To the Planning Officer A/149/20/1
6 Longback Cottages
Angmering

My name is Mr D Spooner of 1 Bewley road Angmering I am a tenant of 1 Bewley Road
This is council owned Property. I wish to Reject the Proposal of 6 Longback Cottages

My Reasons are as follows. to side Extension

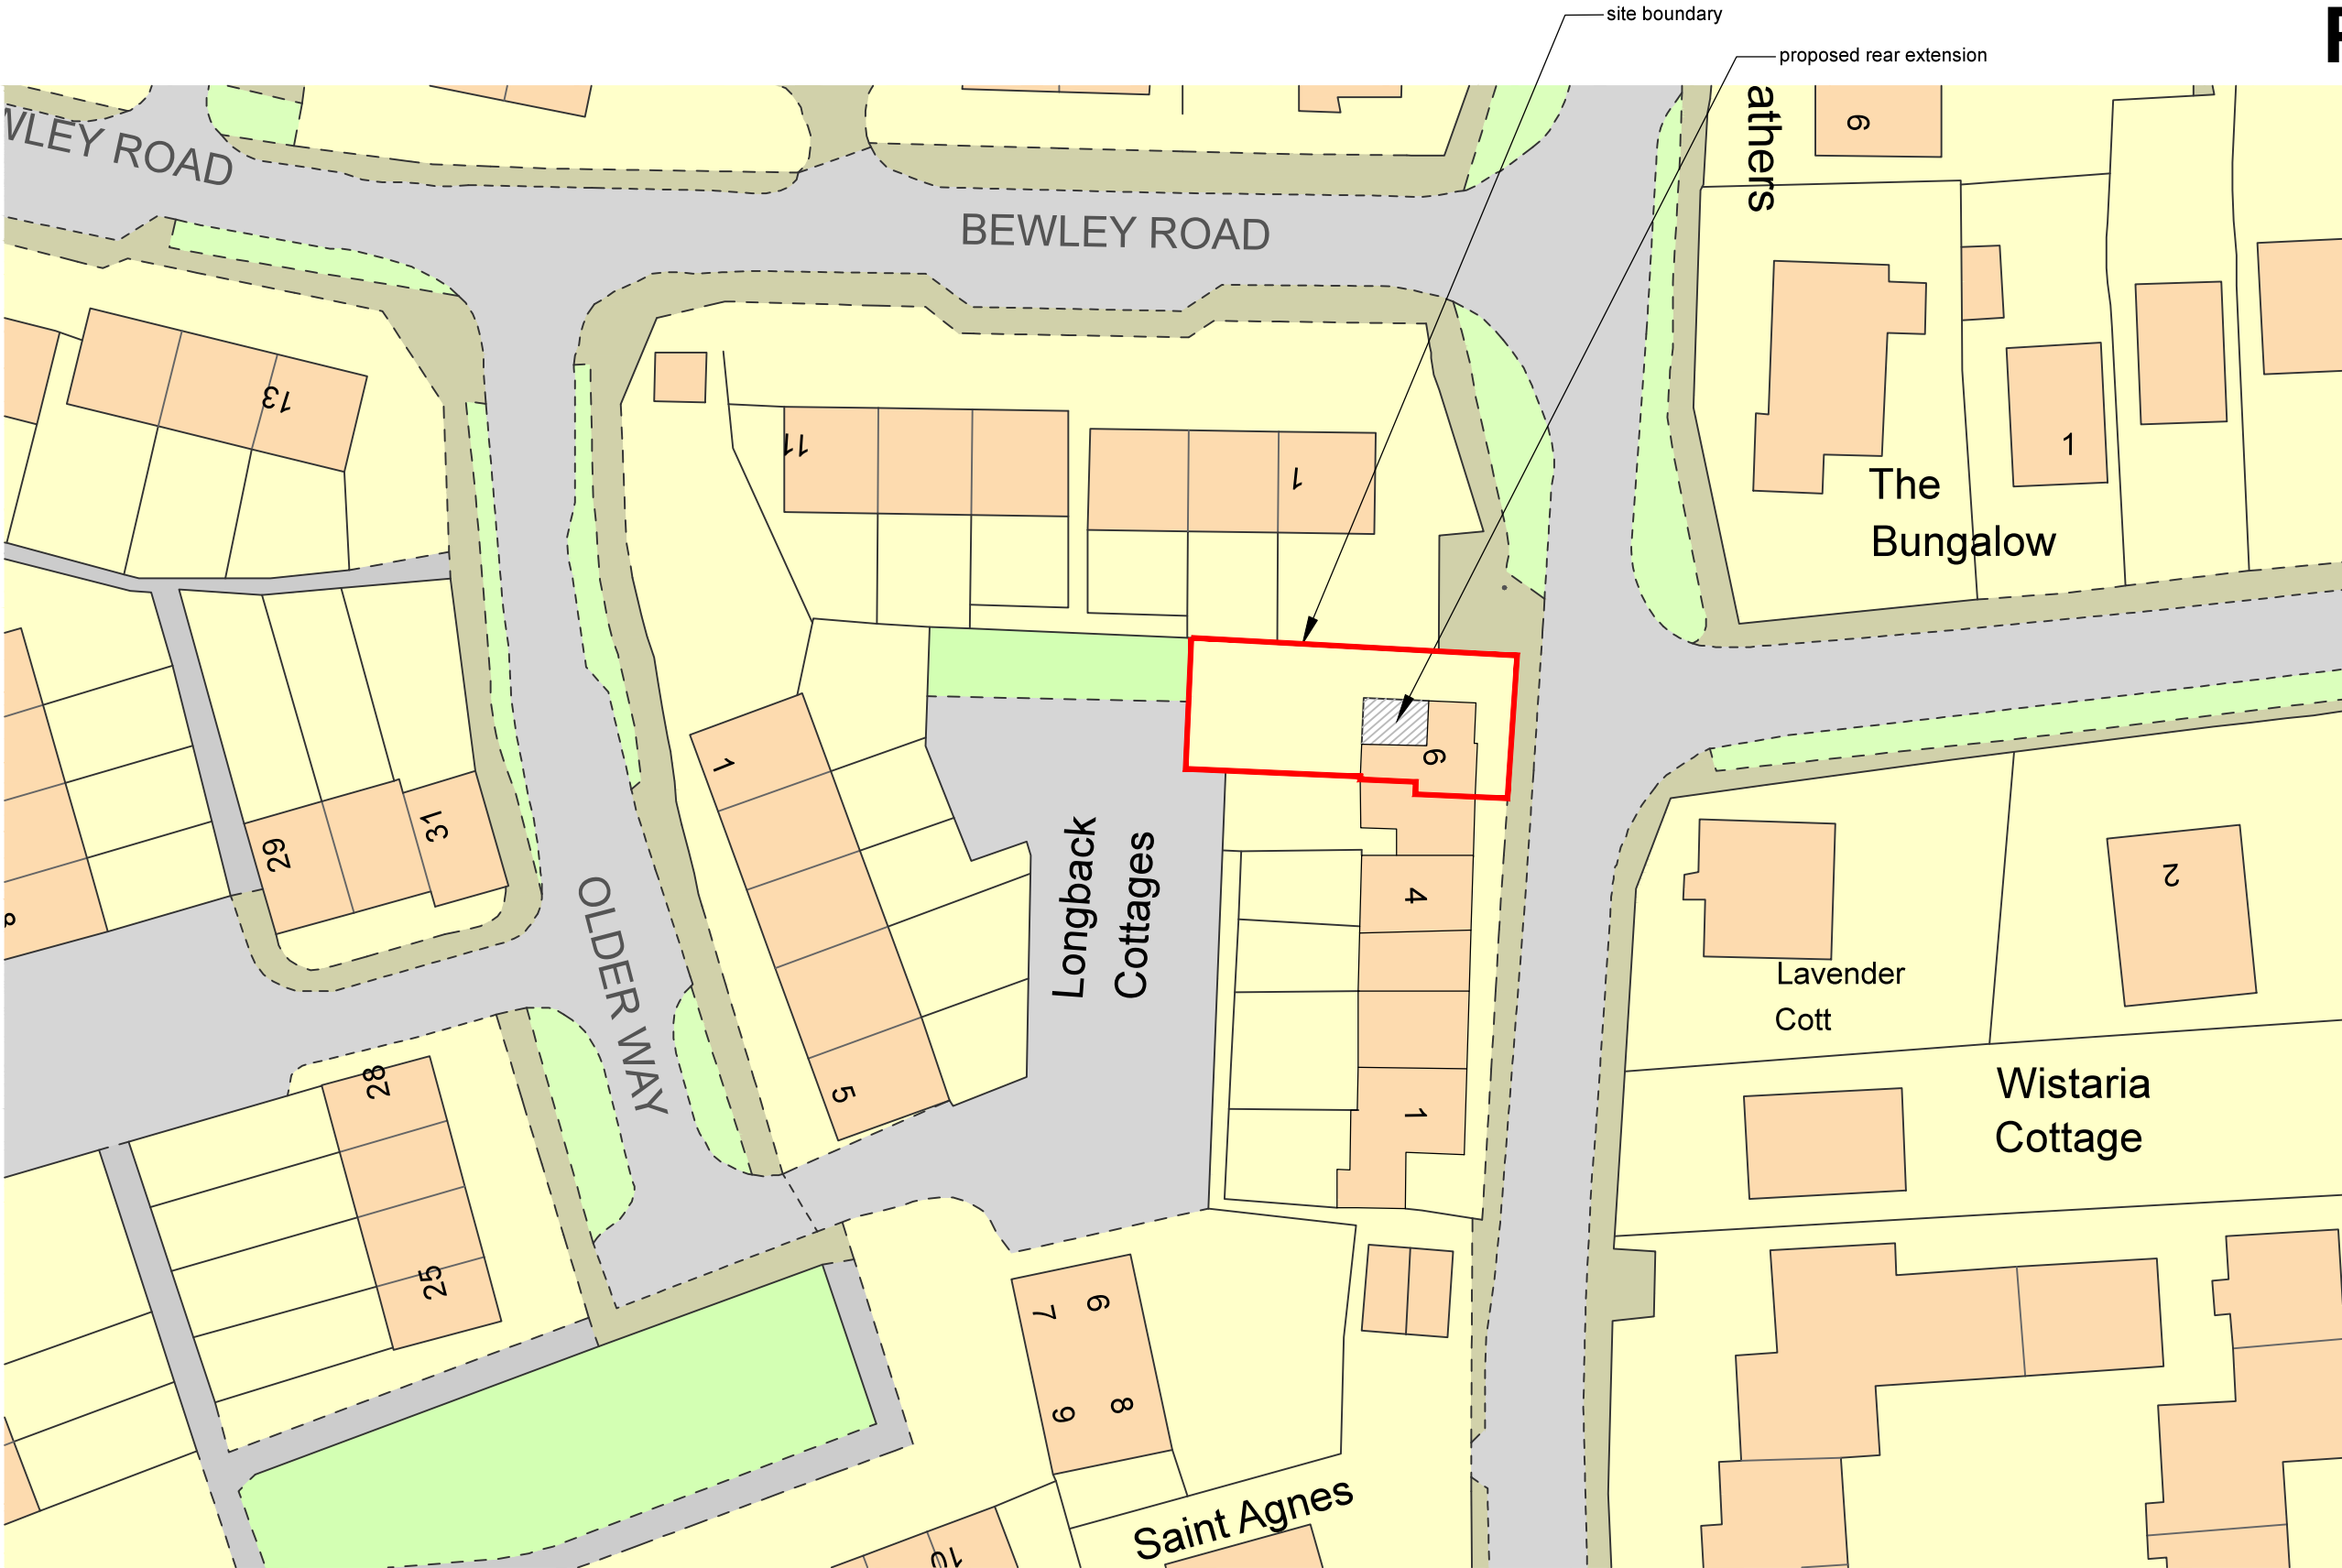
This will stop a lot of light (sun light) to my garden. also if there are windows put in this
build we will be very overlooked.

Tiling or paving the drive will also cause problems, as rainwater will have no where to go.
We are already suffering problems with the Sewers as the main pipe runs under the public
footpath.

The Brick wall Dividing the 2 properties is in the state of Collaps the wall running down the
footpath is tied to the other to hold it up, the wall down the side of 6 Longback is owned by
the owner. The wall along the footpath is owned by Arun Dis Council who Replaced the wall in
2014/2015.

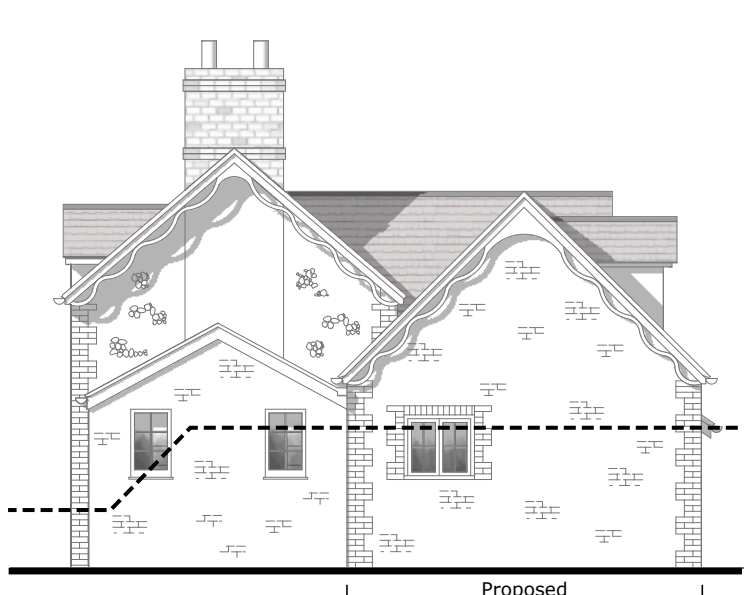
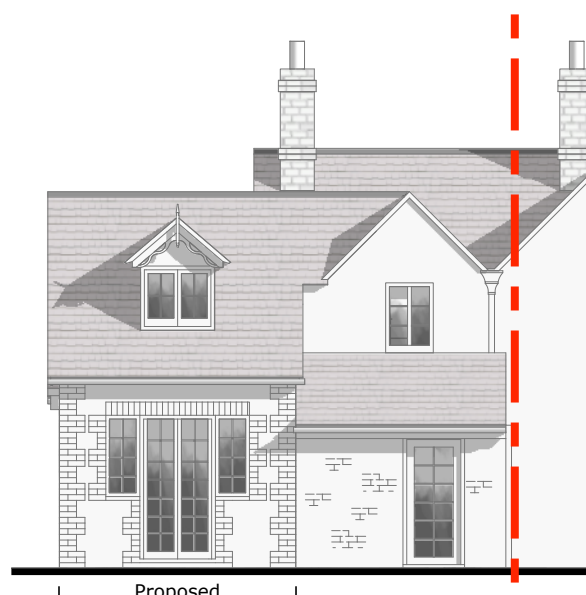
BUT the Side Extension to the Property is a Definite NO.

This Extension is also being rejected by my neighbour Mr Saunders at number 3 Bewley Road it
would be a good thing to send us a copy of the plans, as this New Build will take more light from
our Gardens, also we do not wish to have a Brick wall with possible windows.

We do not want to be overlooked Please take this in to consideration.
